From: [Rachael Stevie \(CD\)](#)
To: "Marcus Ward"
Cc: [Jeremy Johnston](#)
Subject: VA-21-00003 Ward - Application on hold
Date: Friday, April 23, 2021 1:34:00 PM
Attachments: [image001.png](#)

I have sent my Staff Report to our Planning Official for review. He has stated that he does not see a convincing argument that the first two criteria have been met. These issues are noted below.

SITE PLAN

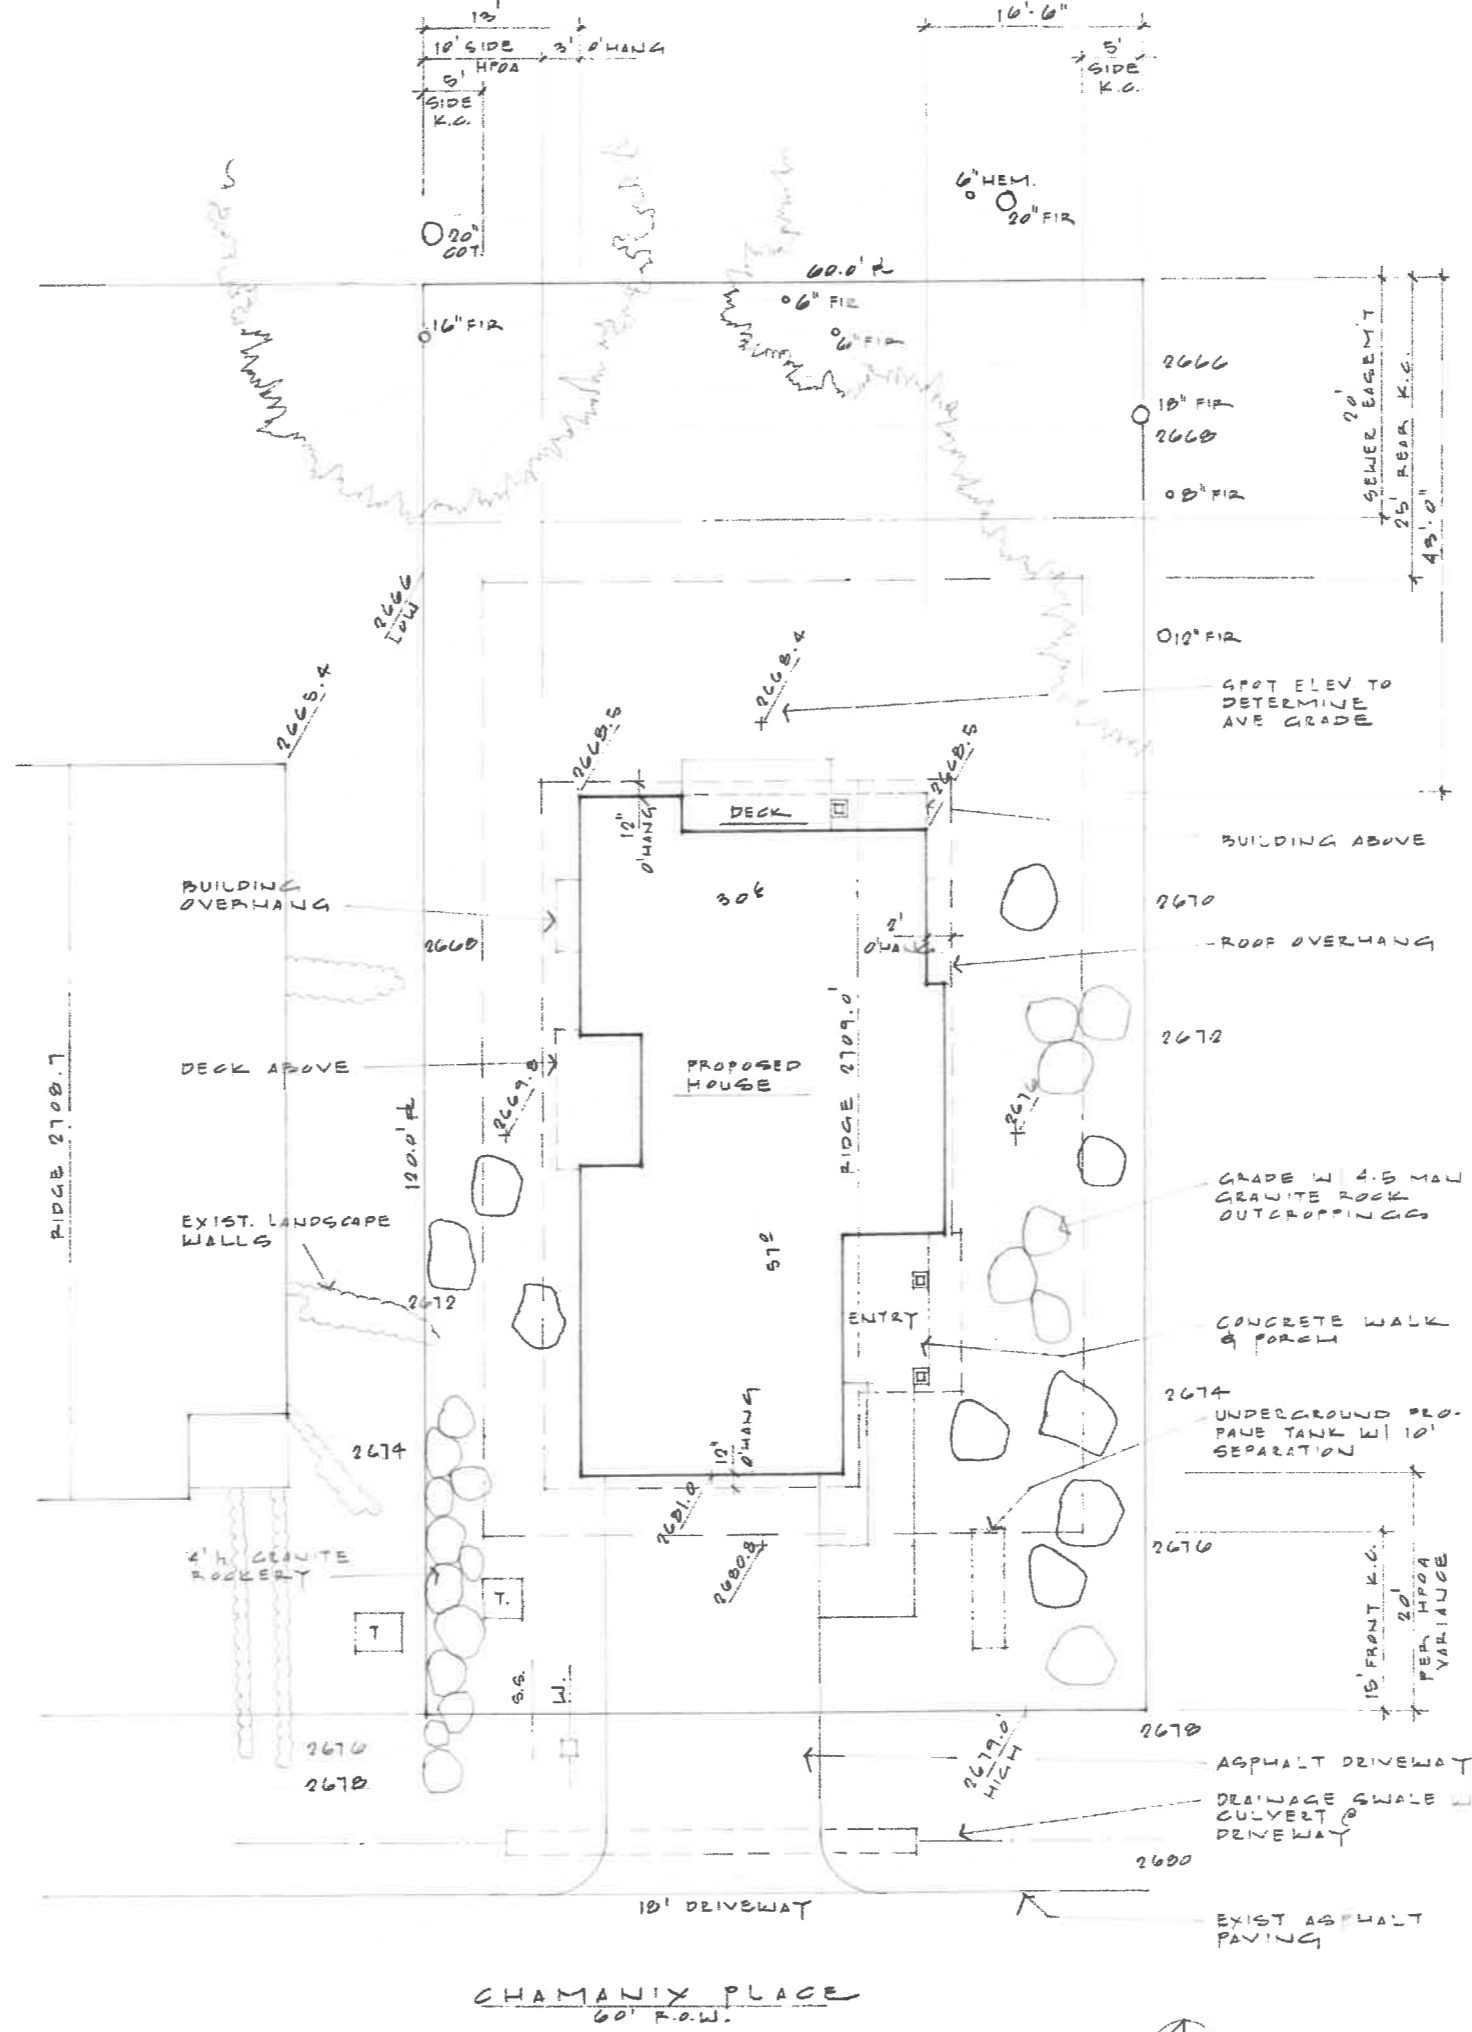
The response provided does not address the criteria. You will need to express how the front setback standard will prevent you from building something comparable to neighbors. A review of adjacent parcel residential structures demonstrate a general range of 1,304 to 2,568 square feet. Your proposal estimates a 2,800 square foot residence. You will also need to demonstrate how this additional square footage is not driving the need for the variance.

# BOUNDARY & TOPOGRAPHIC SURVEY

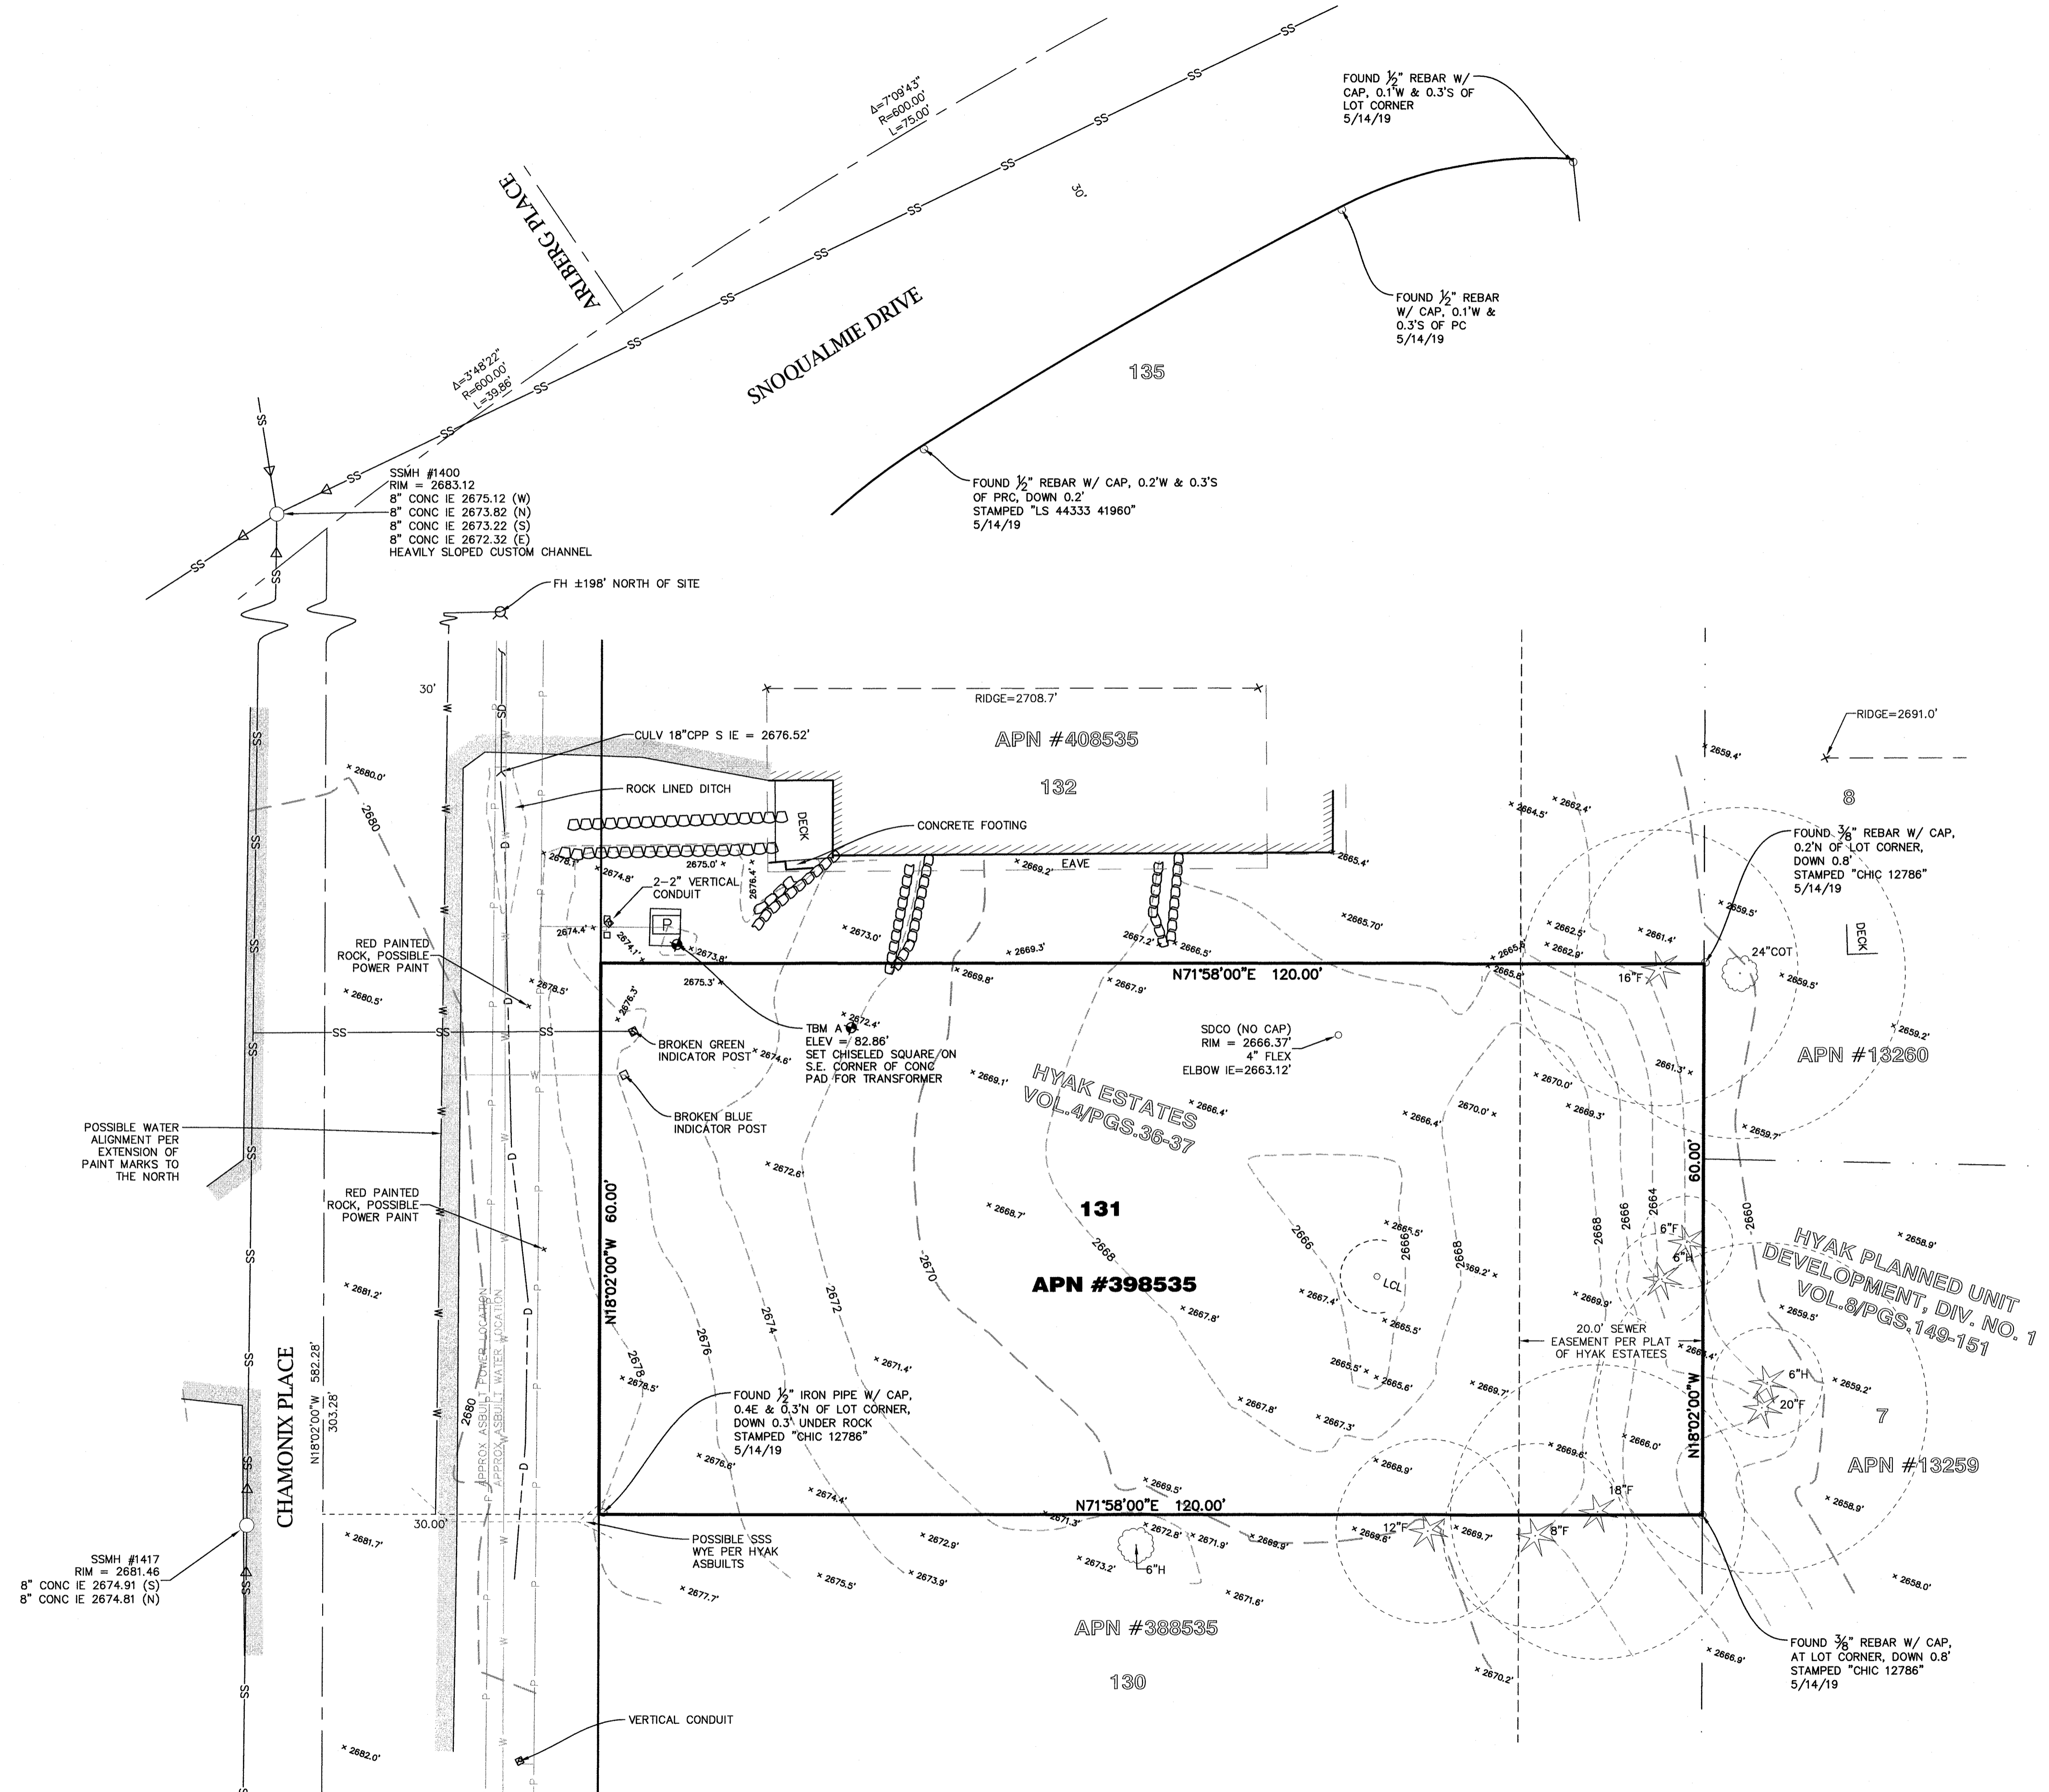
1. Unusual circumstances or conditions applying to the property and/or the intended use that do not apply generally to other property in the same vicinity or district, such as topography. Based on County GIS slope data and the topographic survey you provided, it does not appear there are unusual circumstances relative to adjacent property owners. The slope does not appear excessive and seems generally consistent with neighboring parcels. The application states that the variance is necessary to obtain positive flow and gravity drain to the existing sewer, but no technical materials are provided to demonstrate this. This argument will need to be justified by a qualified engineer to be considered as evidence for consistency with criteria #1.
